SHOPS AT MERIDIAN RANCH CONVENIENCE STORE

LOT 2, THE SHOPS FIL. NO. 1A AT MERIDIAN RANCH

Grading & Erosion Control Plans

V1_GEC Plan.pdf Markup Summary

SITE DEVELOPMENT PLAN

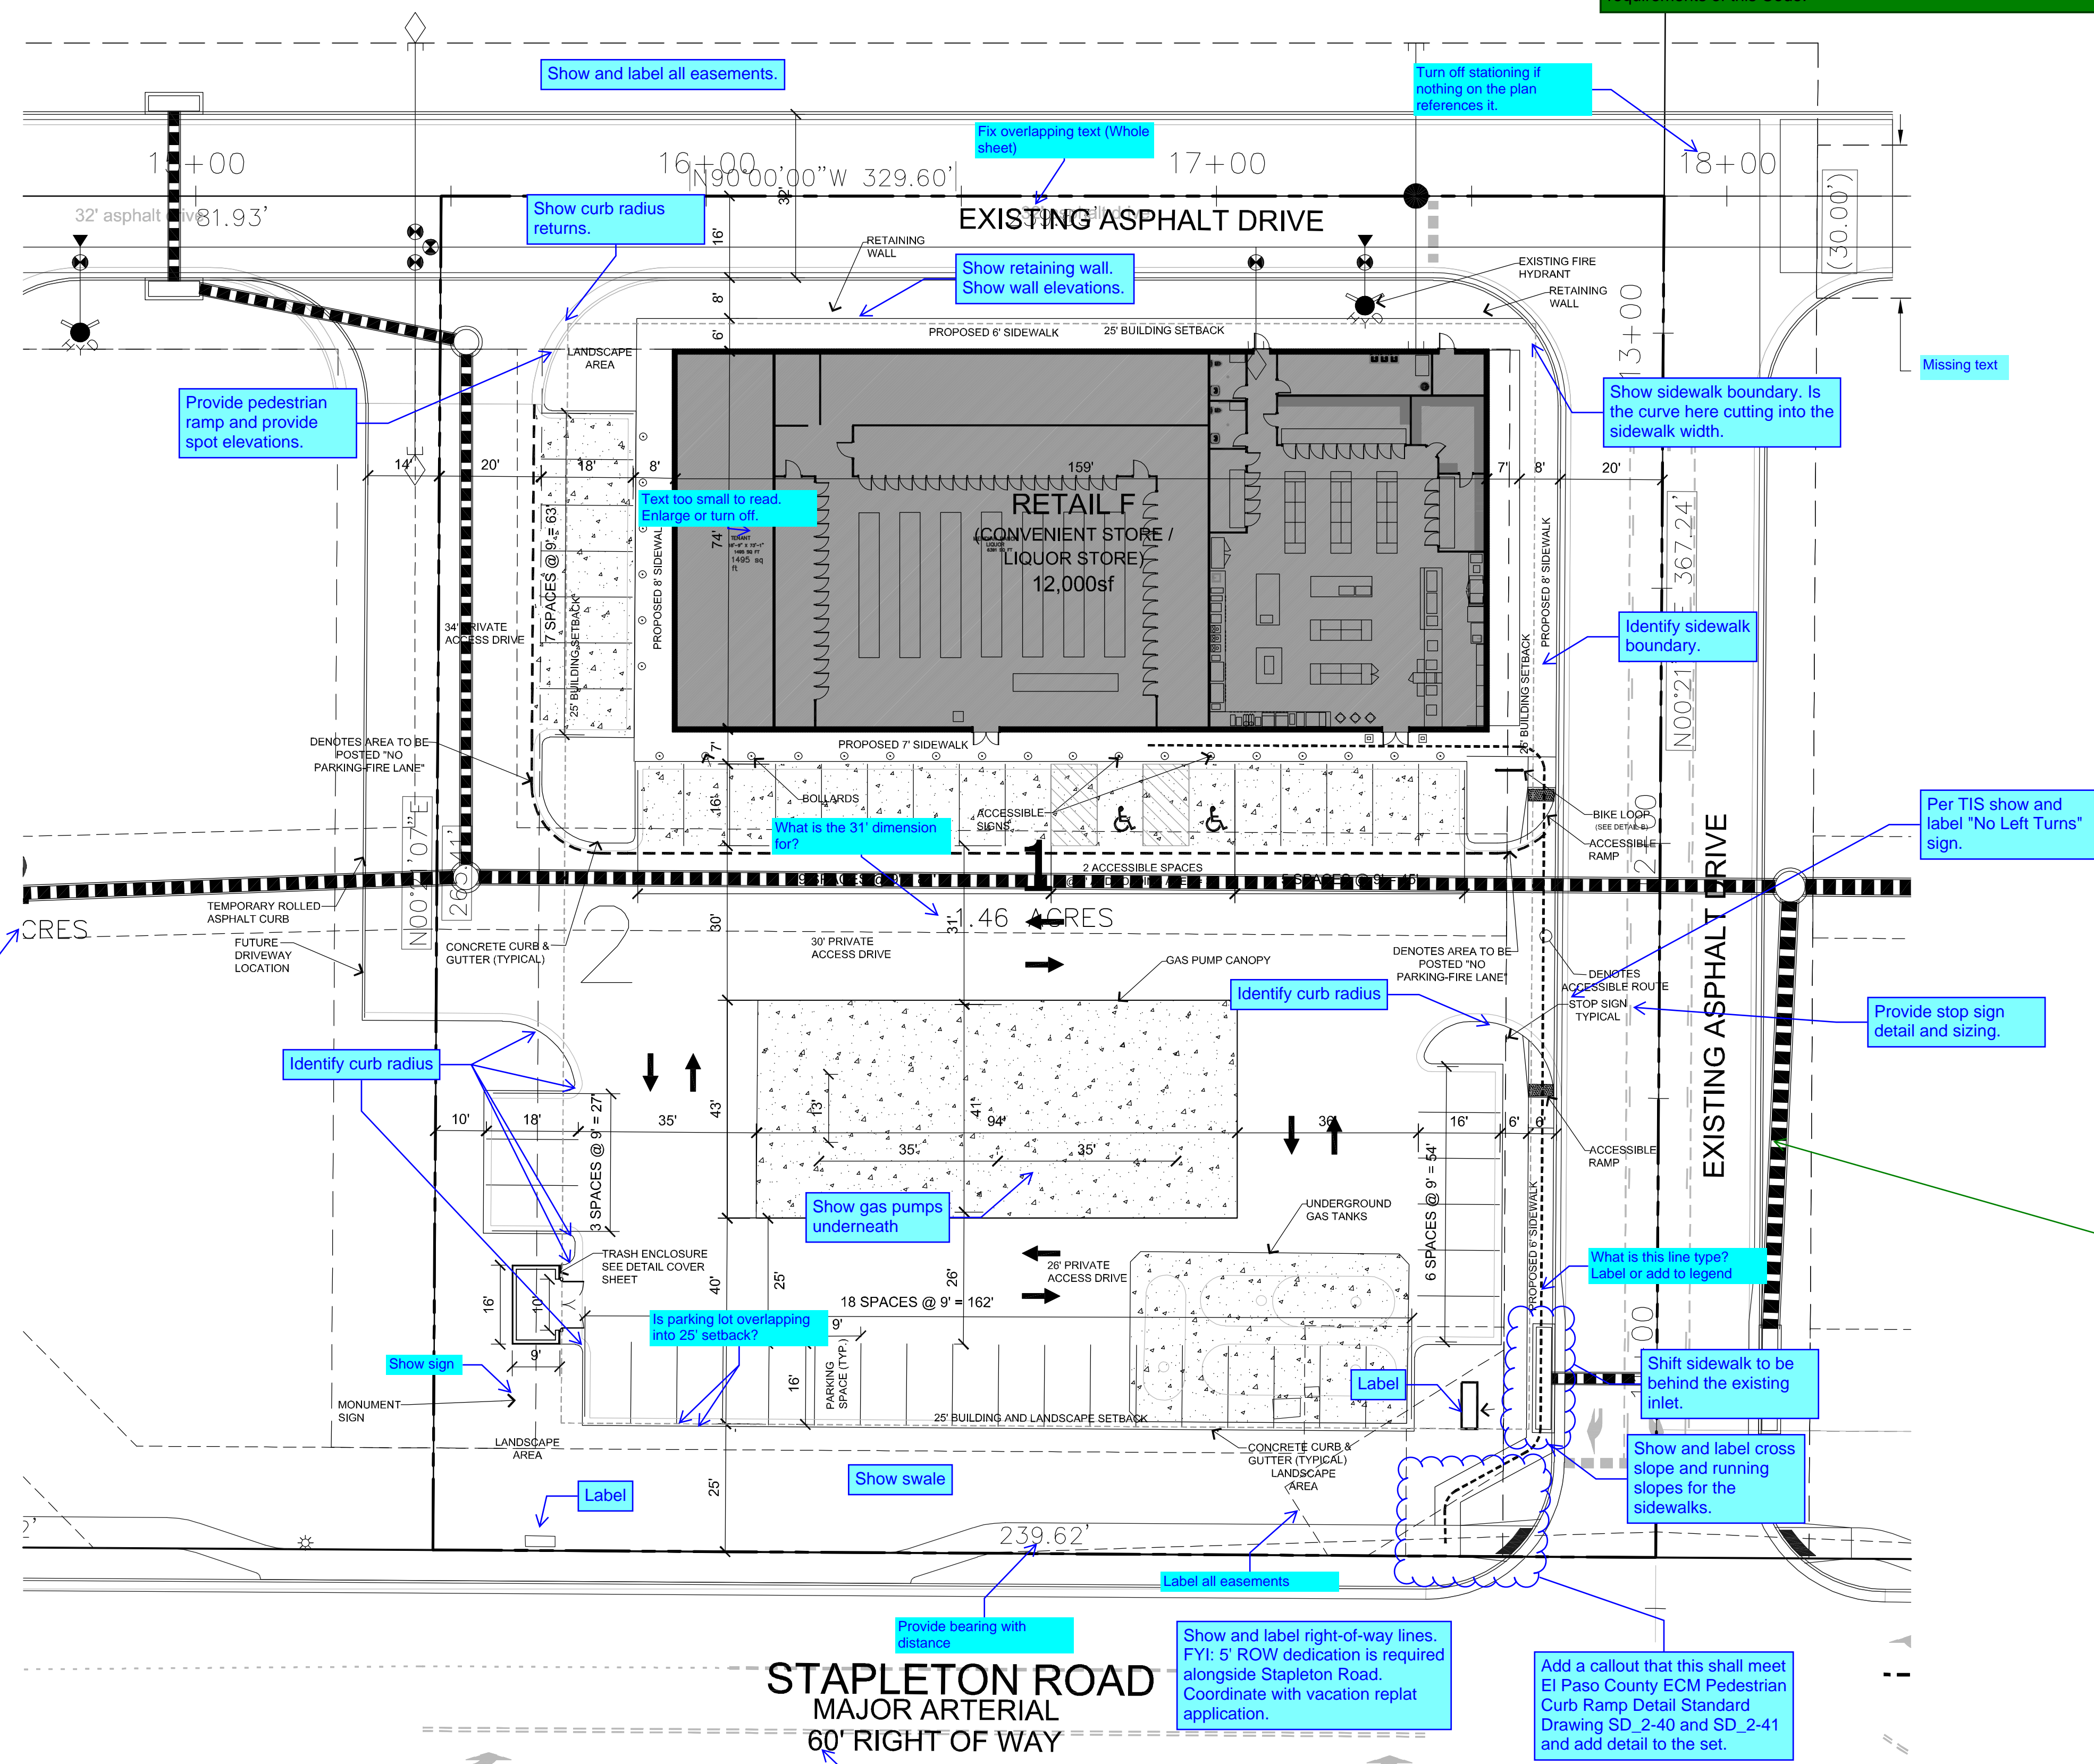
Please verify sidewalk width. Proposed site development plan shows 8' sidewalk width.

Per site development plan, only 50 stalls (2 along front of building are handicap)

Show curb return radius

Show VTC

Show and label sidewalk width at this bend.

DRAWING NO. 2
 LANDSCAPE PLAN

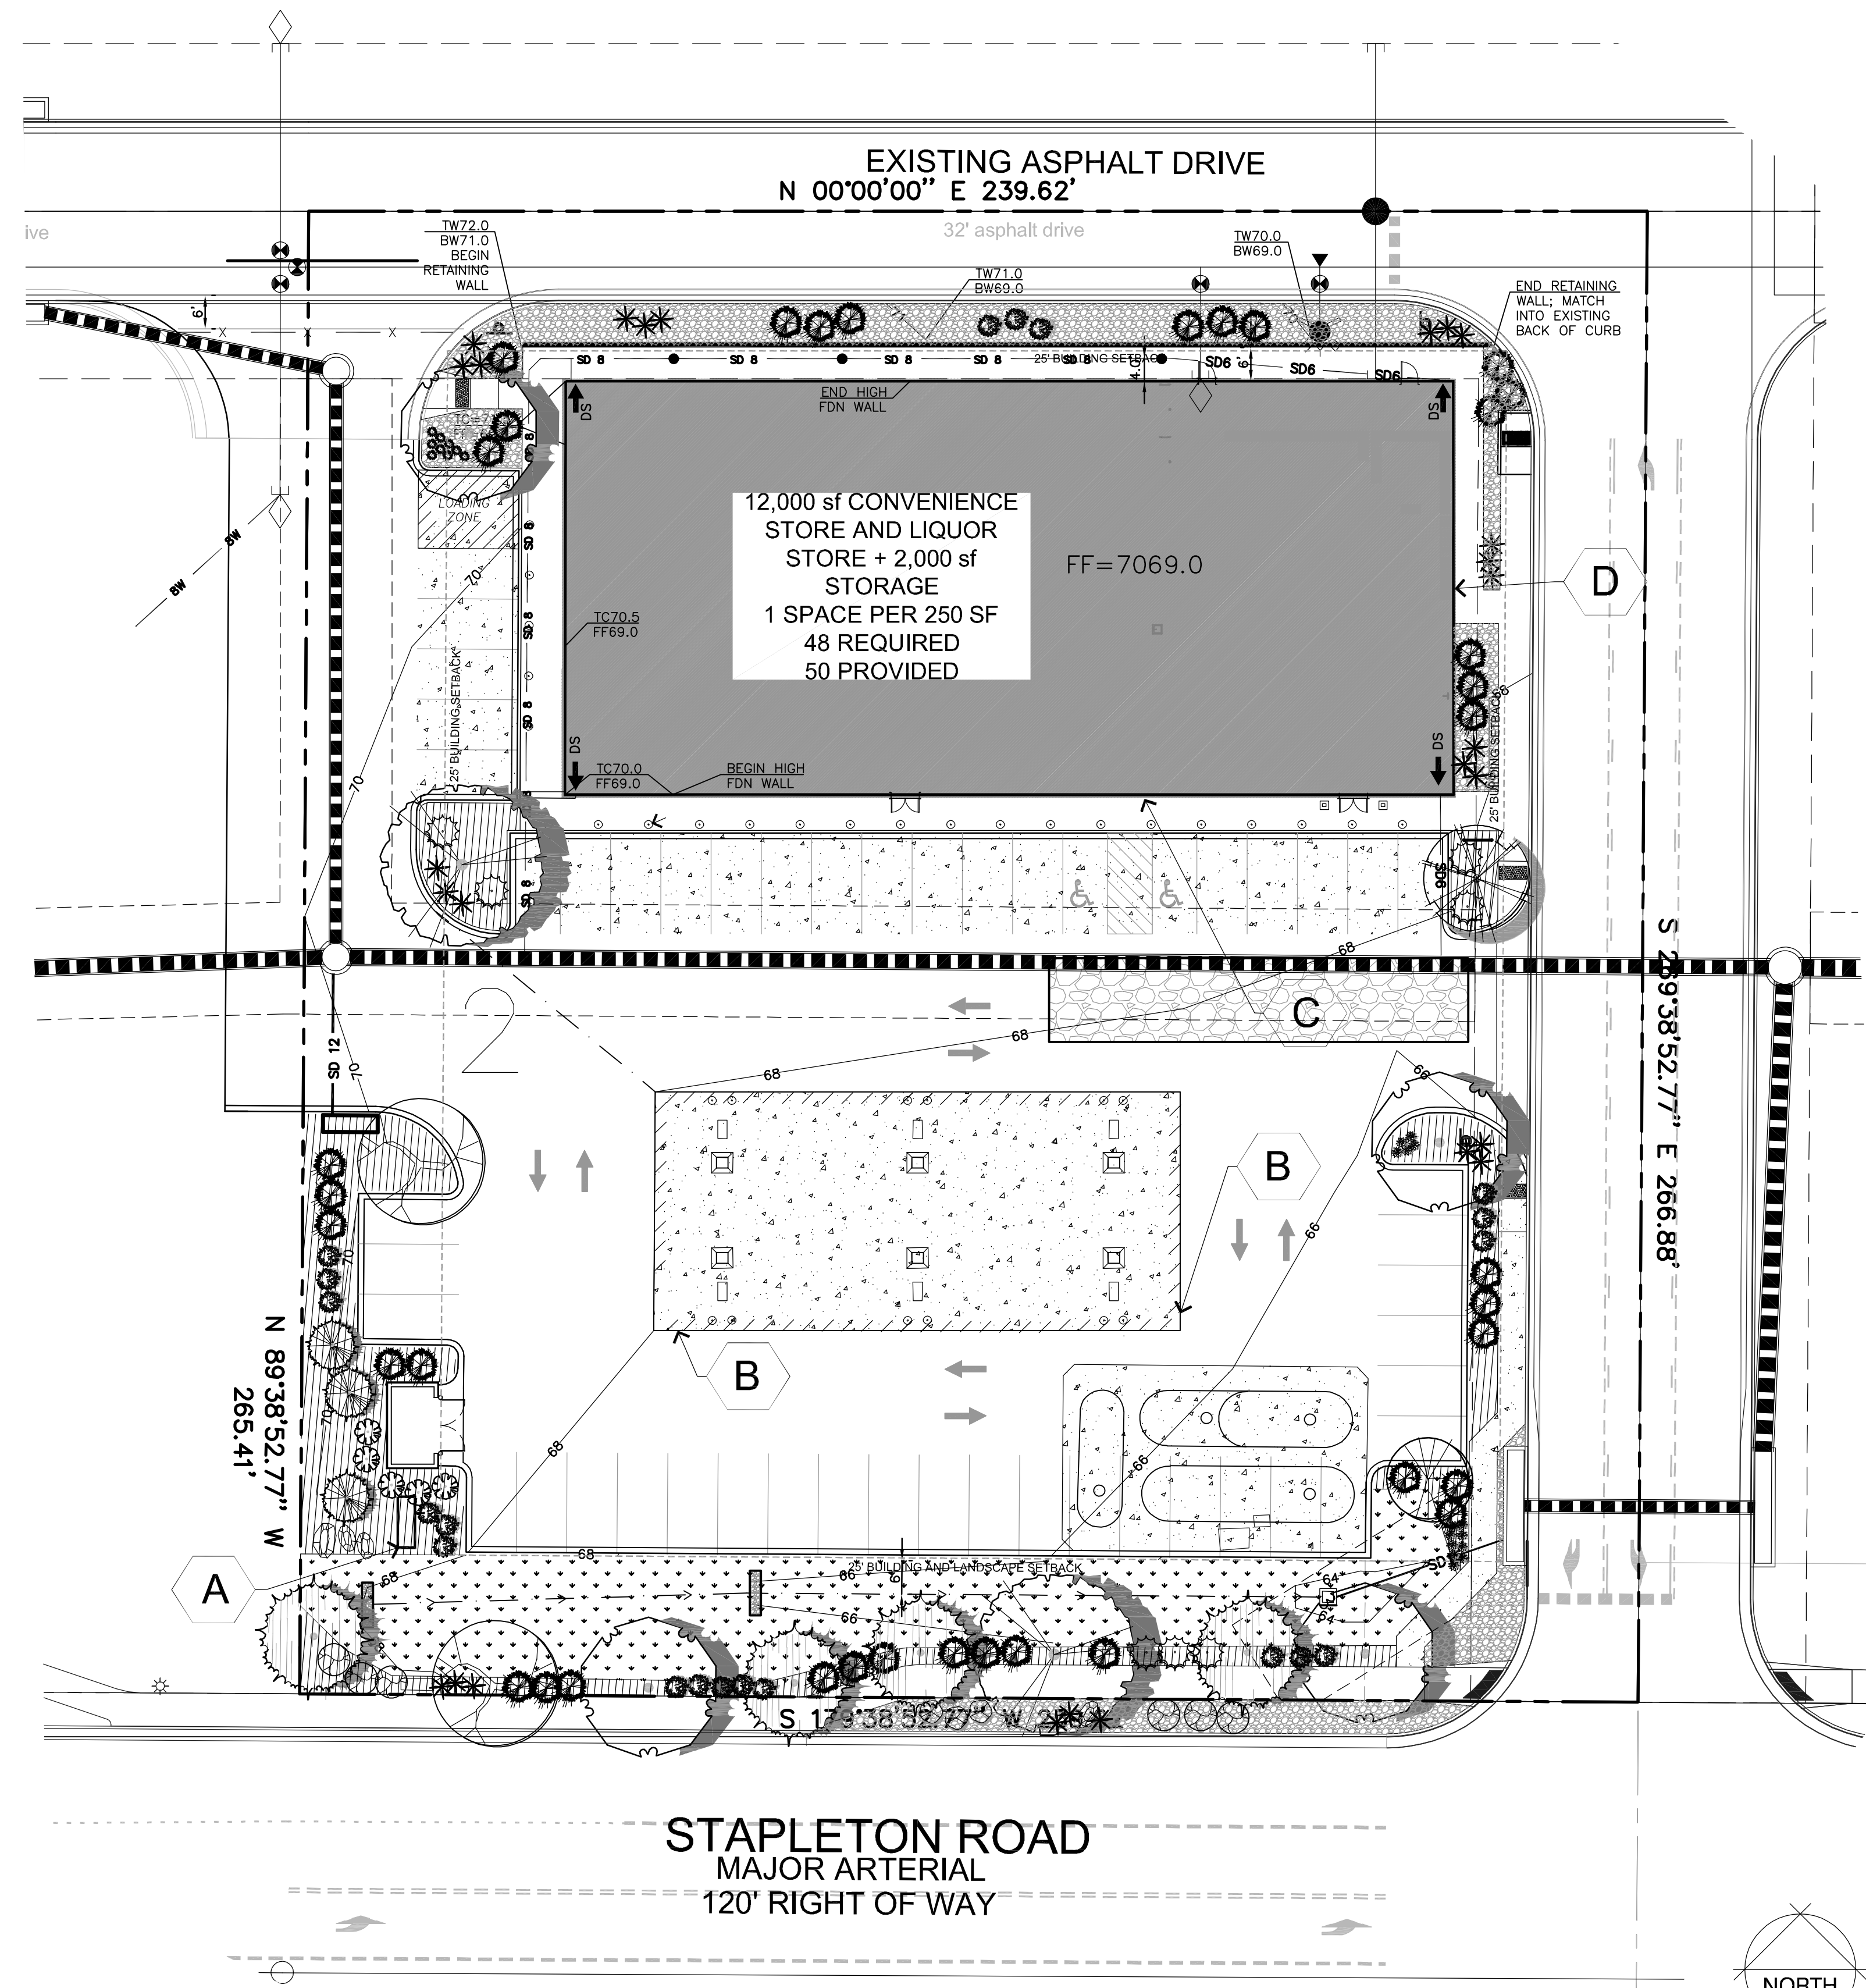
Compare this whole area to what is shown on the Landscape Plan (LP). The LP shows that most of this area will be 2-4" cobble which contradicts the SM shown on this GEC plan. The cobble also wouldn't allow for runoff reduction, which requires turf grass. Revise to remove discrepancies between LP, FDR, and GEC Plan.
